Permit Number: BCOM2211-0002

Description: **30 x 41 youth/class/sunday school building**

Site Address: **579 OLD STAGE RD N**

Applicant: **PLEASANT MEMORY BAPTIST CHURCH**

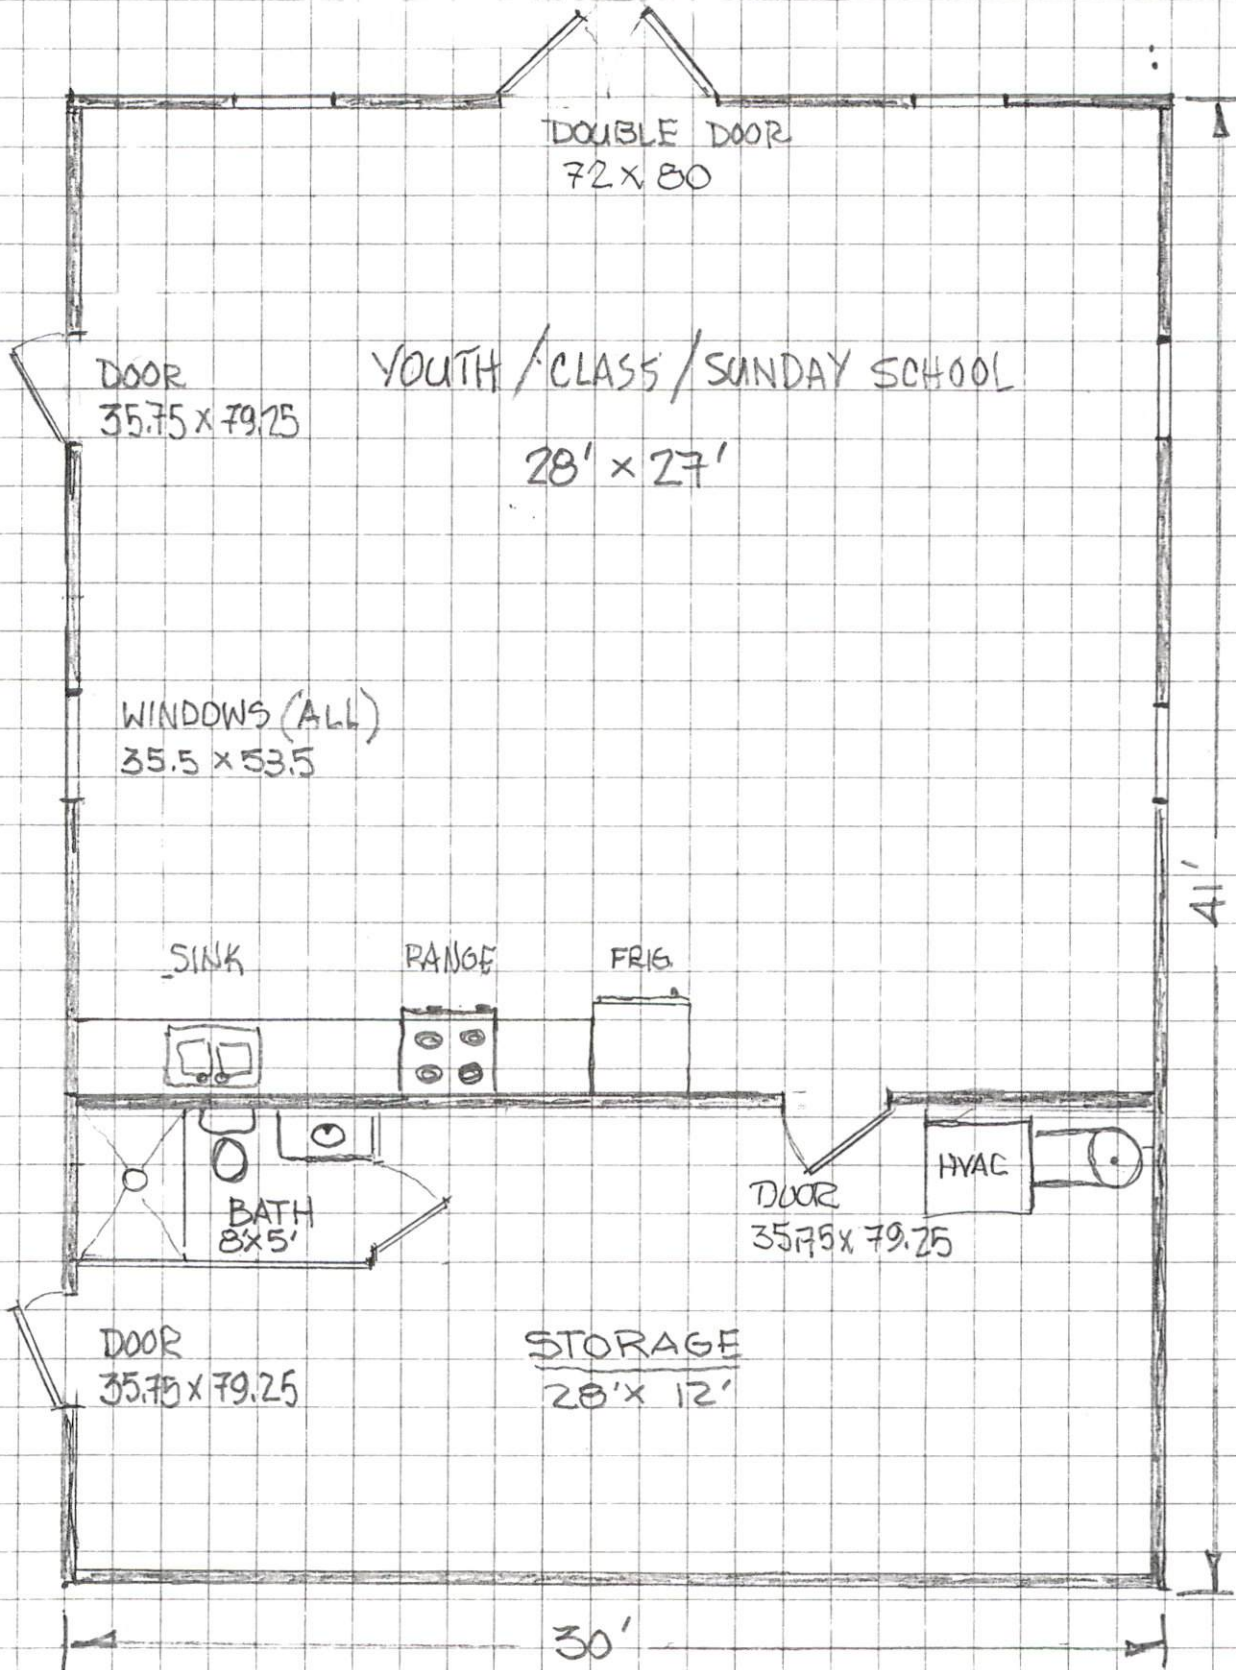
SENT DATE	RETURNED DATE	DUE DATE	TYPE	CONTACT	STATUS	REMARKS
Review Group: AUTO						
11/8/2022	11/8/2022		COMMERCIAL INTAKE	CP Bucket	DISAPPROVED	
Notes:						
11/8/2022	11/9/2022	11/22/2022	COMMERCIAL BUILDING REVIEW	Brad Sutton	DISAPPROVED	
Notes:						
Provide distance from entry door to closest bathroom facility in church building. This building calculates to 50 people @15/sf, so a single restroom would be insufficient.						
11/8/2022	11/9/2022	11/22/2022	FIRE MARSHAL	Roger Sullivan	DISAPPROVED	see notes
Notes:

1. Must be a fire hydrant within 400 feet of the building. 2. Need to submit a life safety plan showing exit signs, emergency lighting, travel distances to exits, square footage, fire extinguisher placement and classroom layout if walls will be constructed for Sunday school classrooms. 3. Need to know what the original use of the building was, possible change of use.						
11/9/2022			Commercial Building Review	Building Bucket		
Notes:
